From: Anita Gardner
Sent: 07 March 2018 12:35
To: Planning.Responses
Subject: FW: FG/115/17/PL : Ferringham Lane
Attachments: 628-06 Rev. A.pdf

From: Sarif Easmon-Dura [REDACTED]
Sent: 06 March 2018 18:24
To: Anita Gardner
Cc: Simone Cornell; Steve Sparky
Subject: Re: FG/115/17/PL : Ferringham Lane

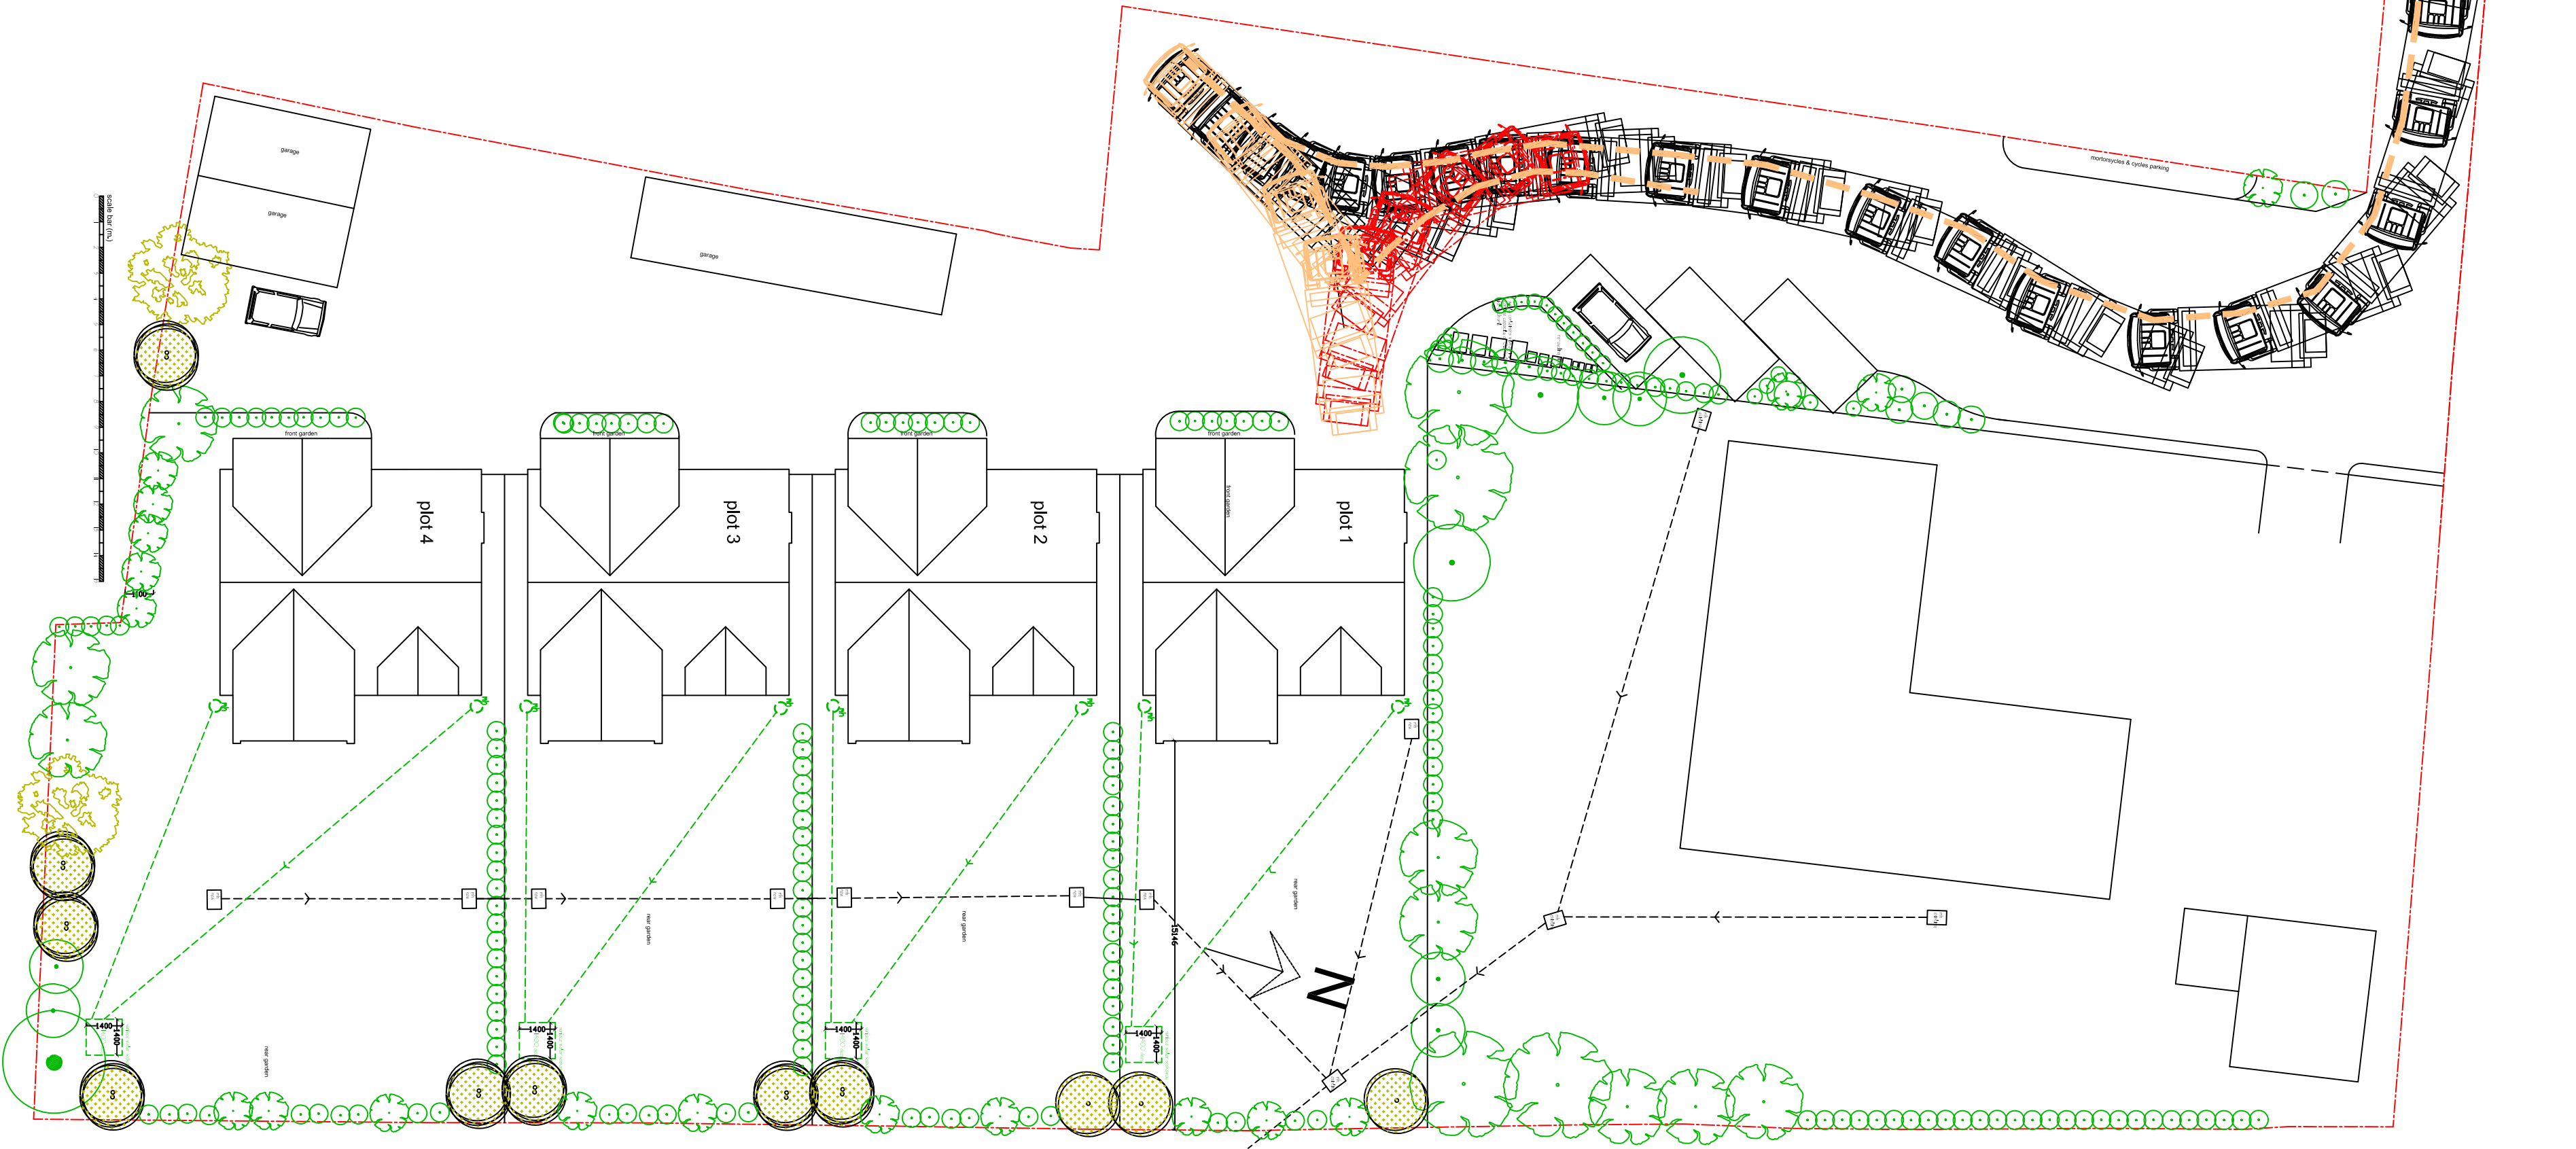
Drawing 628-06 does not indicate the internal surfaced roadway within the site or identify any landscaping along the western boundary with Ferringham Lane. Am I to assume that no landscaping is proposed along this boundary and that the whole of this roadway will be hard surfaced ?

Please find attached revised drawing 628-06 Rev. A showing the existing plants at the west boundary. The intention is to retain this green boundary treatment.

In shunting plot 1 & 2 westward to achieve 22m between properties at the rear, this reduces the front soft landscape. However, there is scope to the front of plots 3 & 4 to have a larger front green spaces. But I sincerely hope this is not an issue to affect the outcome of our proposal.
